Planning Department
Brennon Williams, Director

September 3, 2020

Re: Dorado Montano Townhomes – 6200 Montano Rd NW
Erosion Sediment Control Plan
Engineer's Stamp Date 8/24/2020 (E10E079)

TEMPORARY EROSION AND SEDIMENT CONTROL PLAN

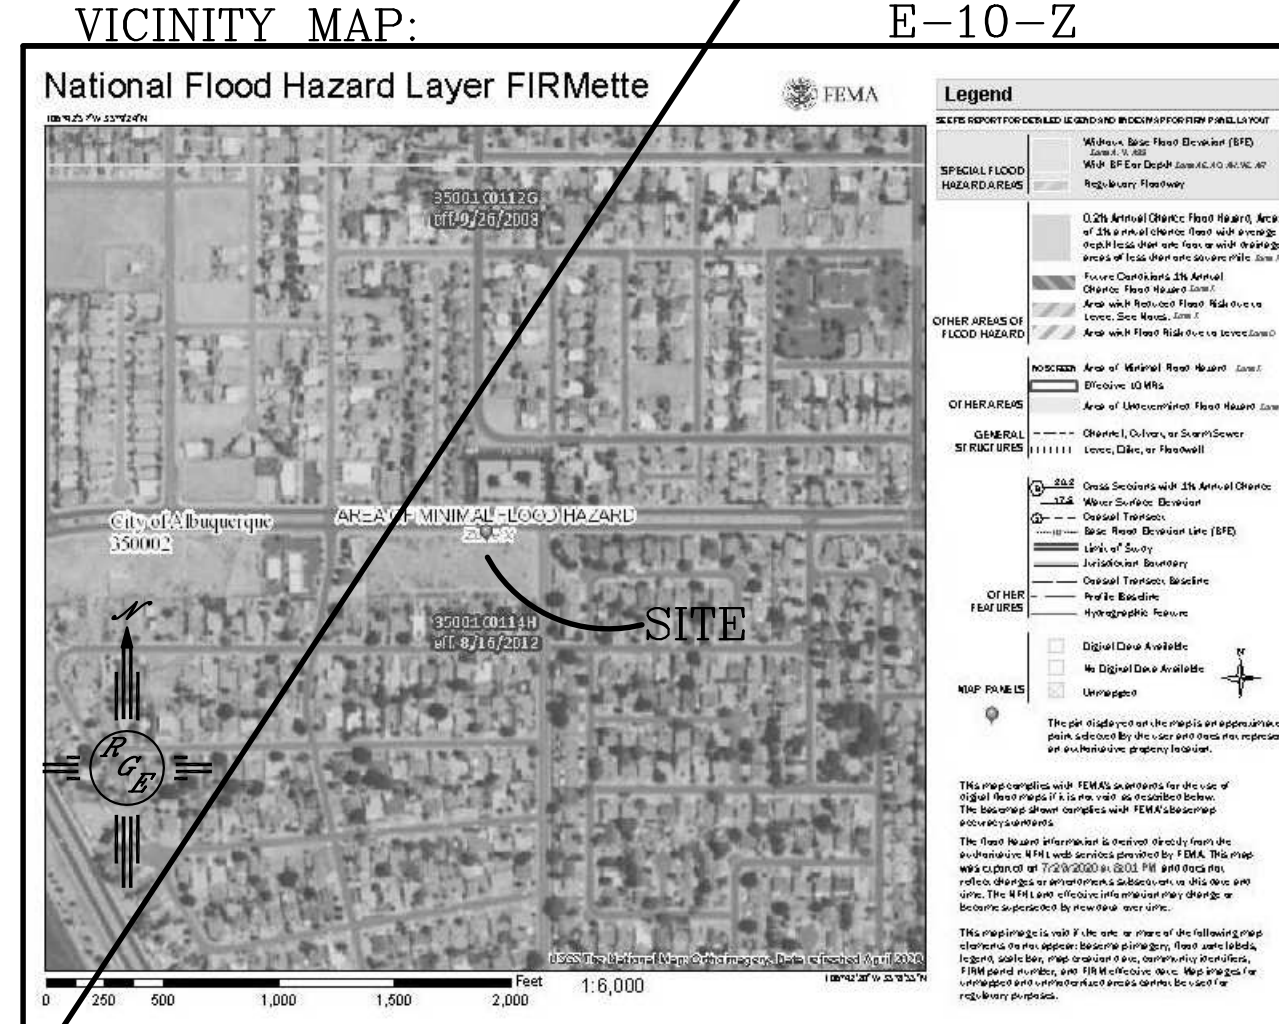
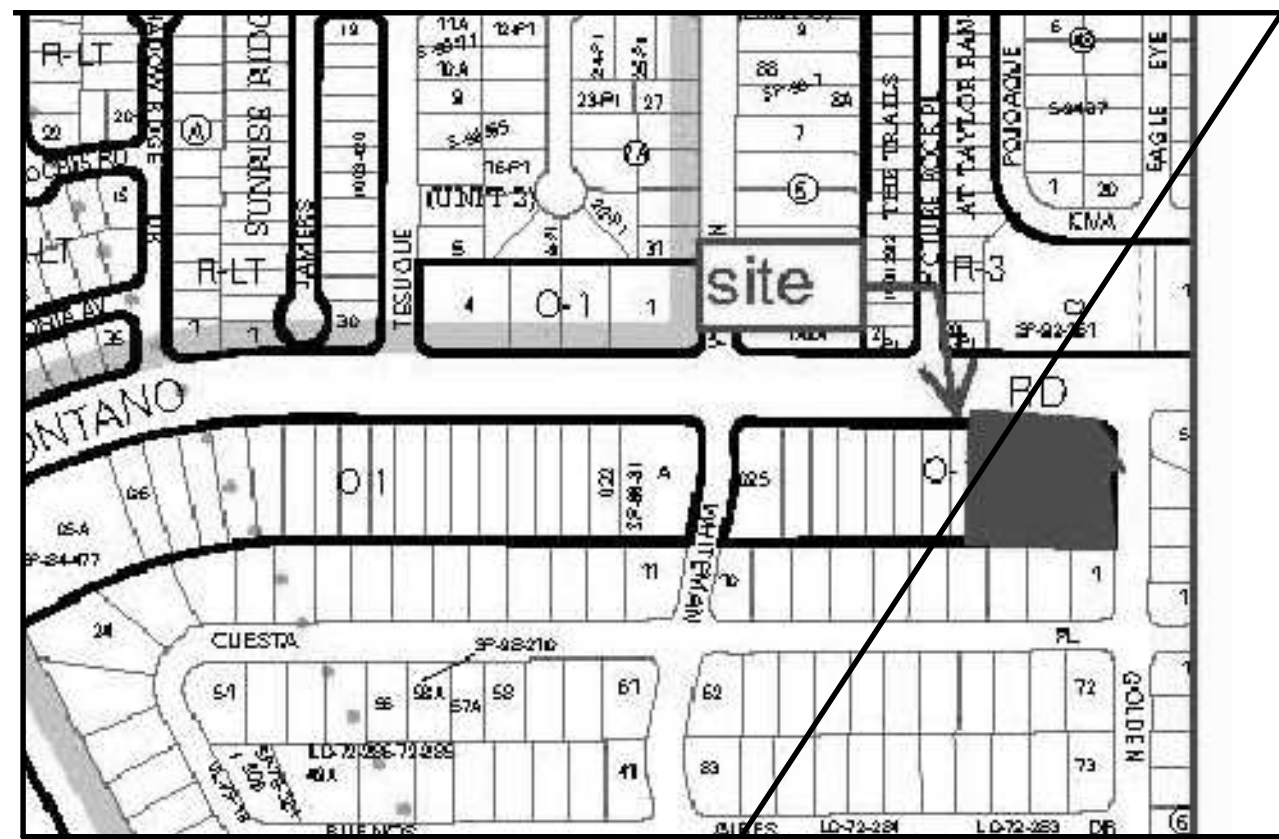
2. The application may need to be revised. It is not clear if this is going to be townhouses or condos. All of the property lines need to be shown on the plan if this is a townhouse development, and a townhouse development will need to show separate phases for the infrastructure and the house construction with separate operators for the two phases. Additional review fees will be required for the infrastructure phase if it is townhouses. If it is condos the multi-family box should be checked on the application form instead of the single family box, but there would be no additional inspection fee.

The BMP design seems adequate, but corrections need to be made to the base map, the date of the signature updated, application form and NOIs updated, and review fee paid. Please resubmit after the G&D Plan has been reviewed by Hydrology and the Site Plan/Plat has been reviewed by DRB.
